## Online Comment

**Application** H16-1089-25  
**Location** BRIDGE FARM HOLBEACH ROAD SPALDING PE12 6JP  
**Proposal** Proposed conversion of existing barns to office use and the development of a padel club on adjacent land

**Name** Greg Watkinson  
**Address** Conservation Officer

**Date Submitted** 08-12-25  
**For/Against** Comments

EXISTING SITE PLAN
SCALE: 1:200

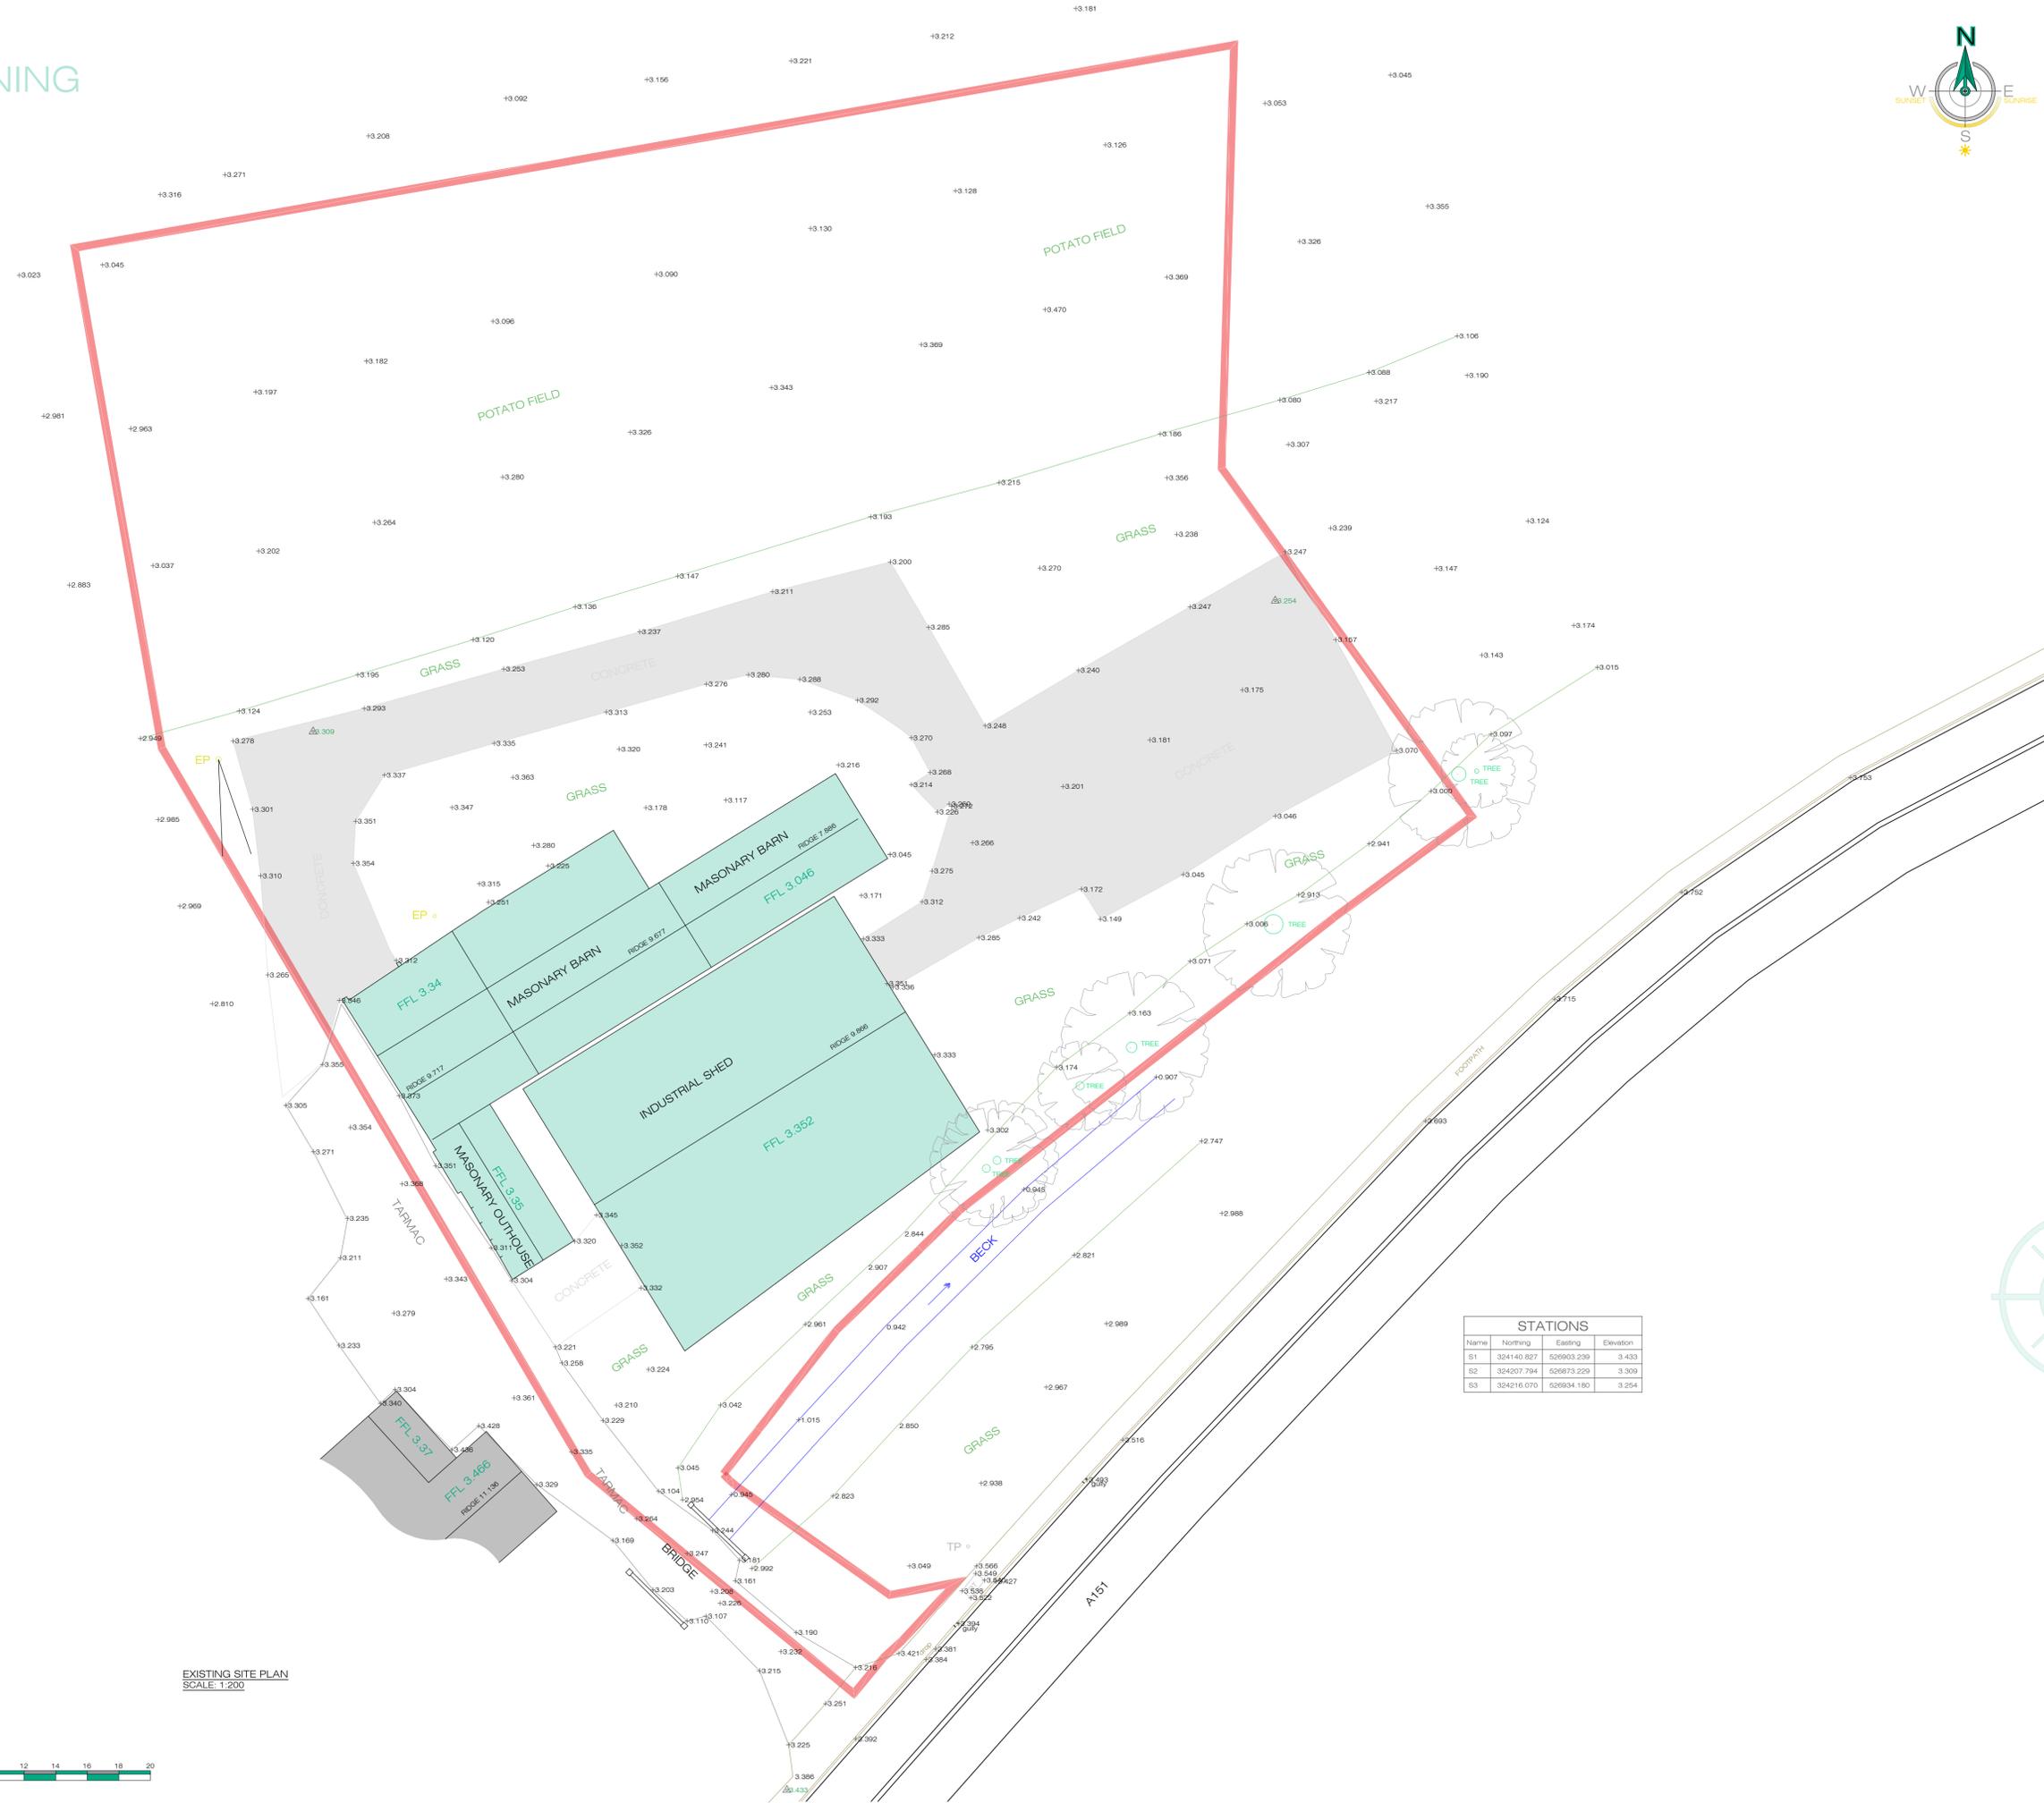
Whilst the site is an NDHA, it is welcomed that the only proposed demolition is of the later, unsympathetic corrugated agricultural buildings, and the original 19th and early C20th brick built buildings - of value to the site - are proposed to be retained and converted. Nevertheless, I do concur with and mirror the comments provided by my colleagues in the LCC Historic Places Team in requesting a site-wide Level 3 building recording prior to any demolition works.
